KITTITAS COUNTY

MEMORANDUM

TO: All Staff
FROM: Public Works Plan Review Team
DATE: May 18th, 2023
SUBJECT: BL-23-00006 Williams

SITE PLAN

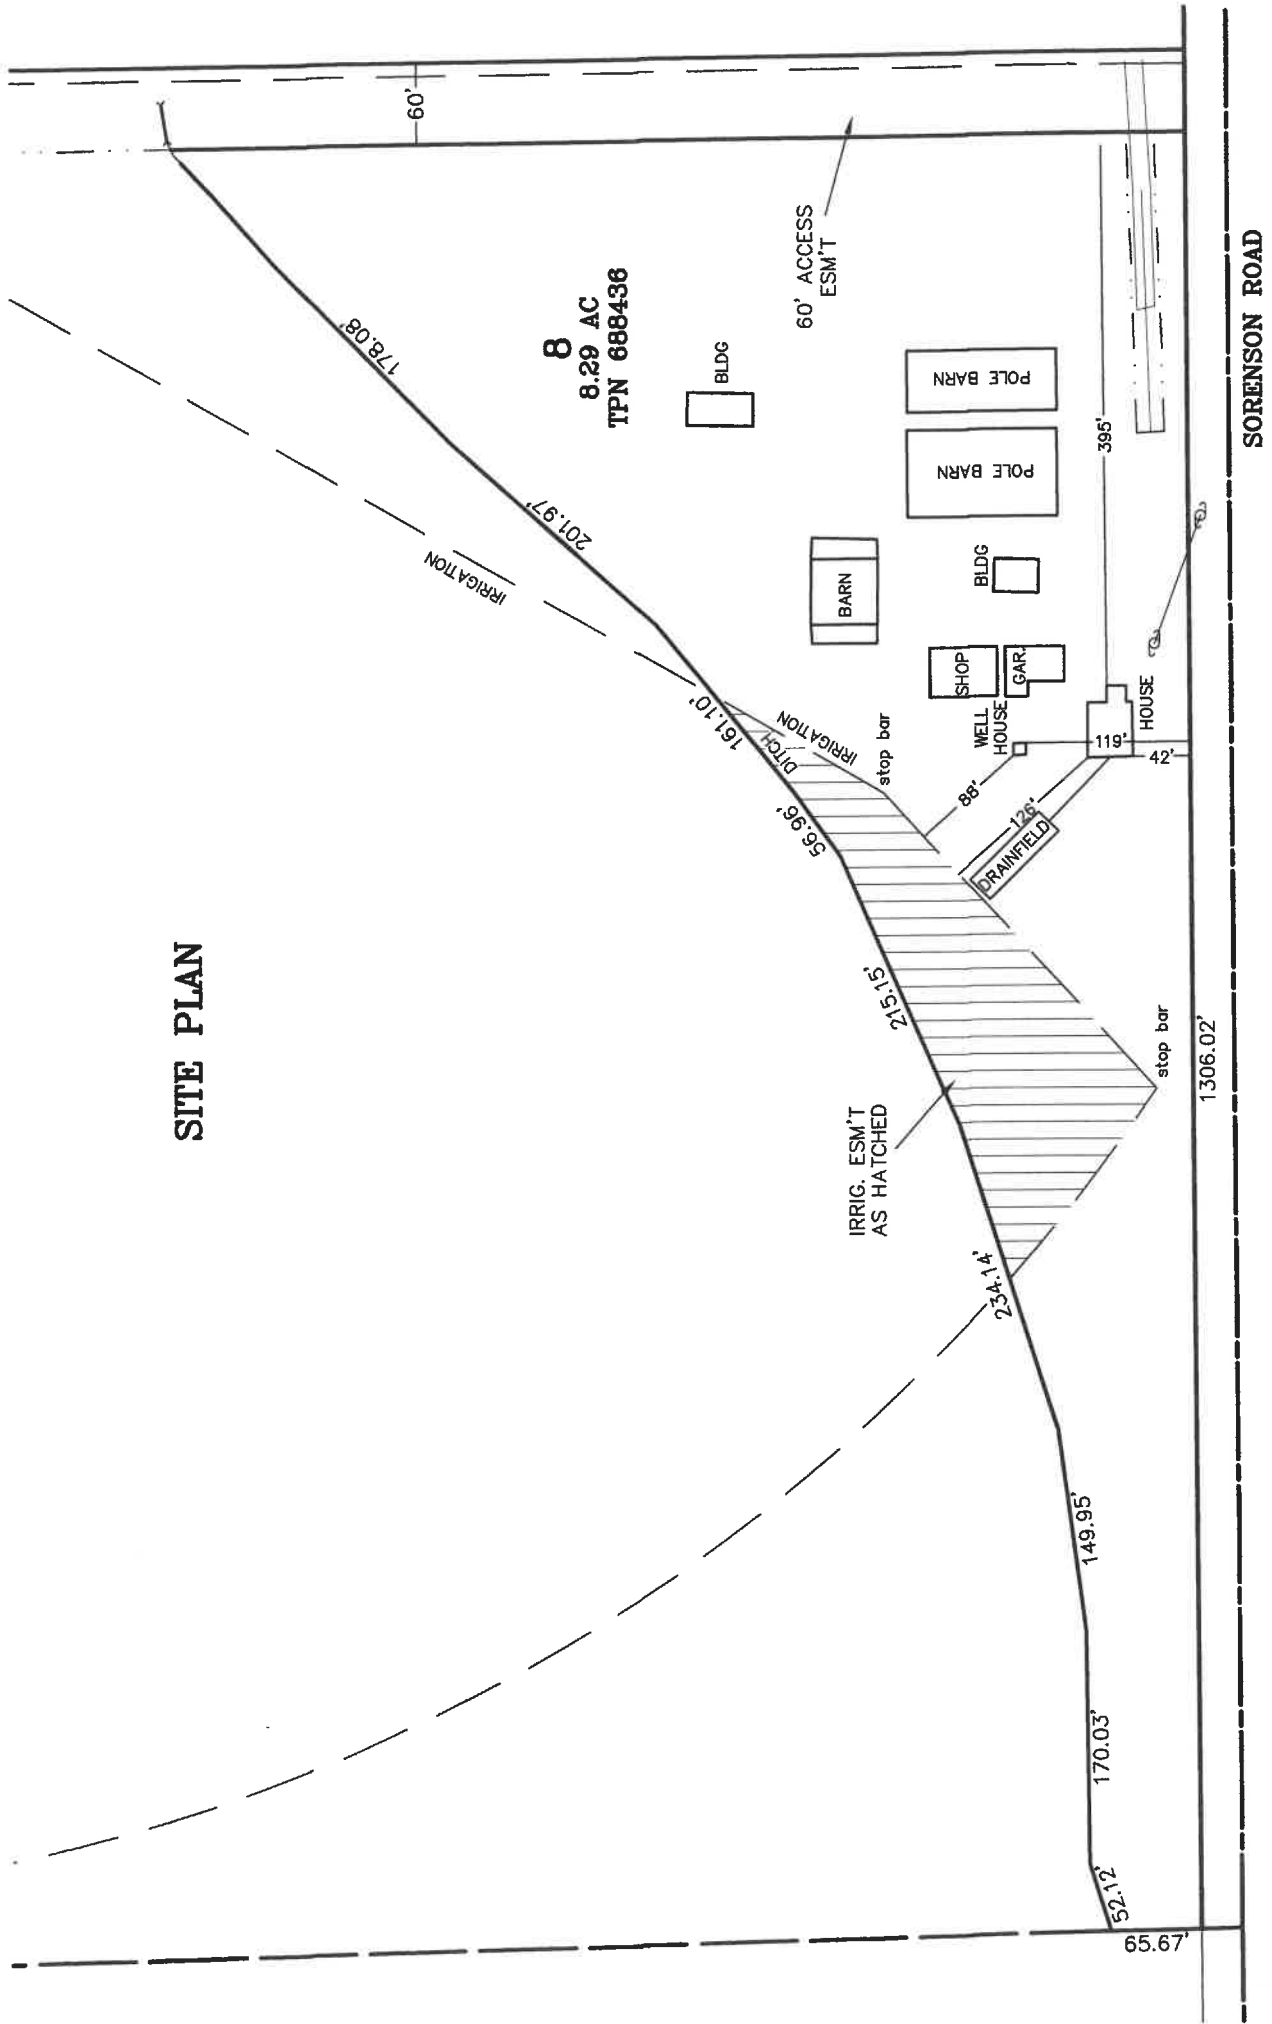
| SURVEY | <p>As the application is ambiguous regarding existing and proposed boundary lines, I suggest resubmittal of this application.</p> <p>As no survey map was provided, additional survey comments are reserved until final. (JT)</p> |
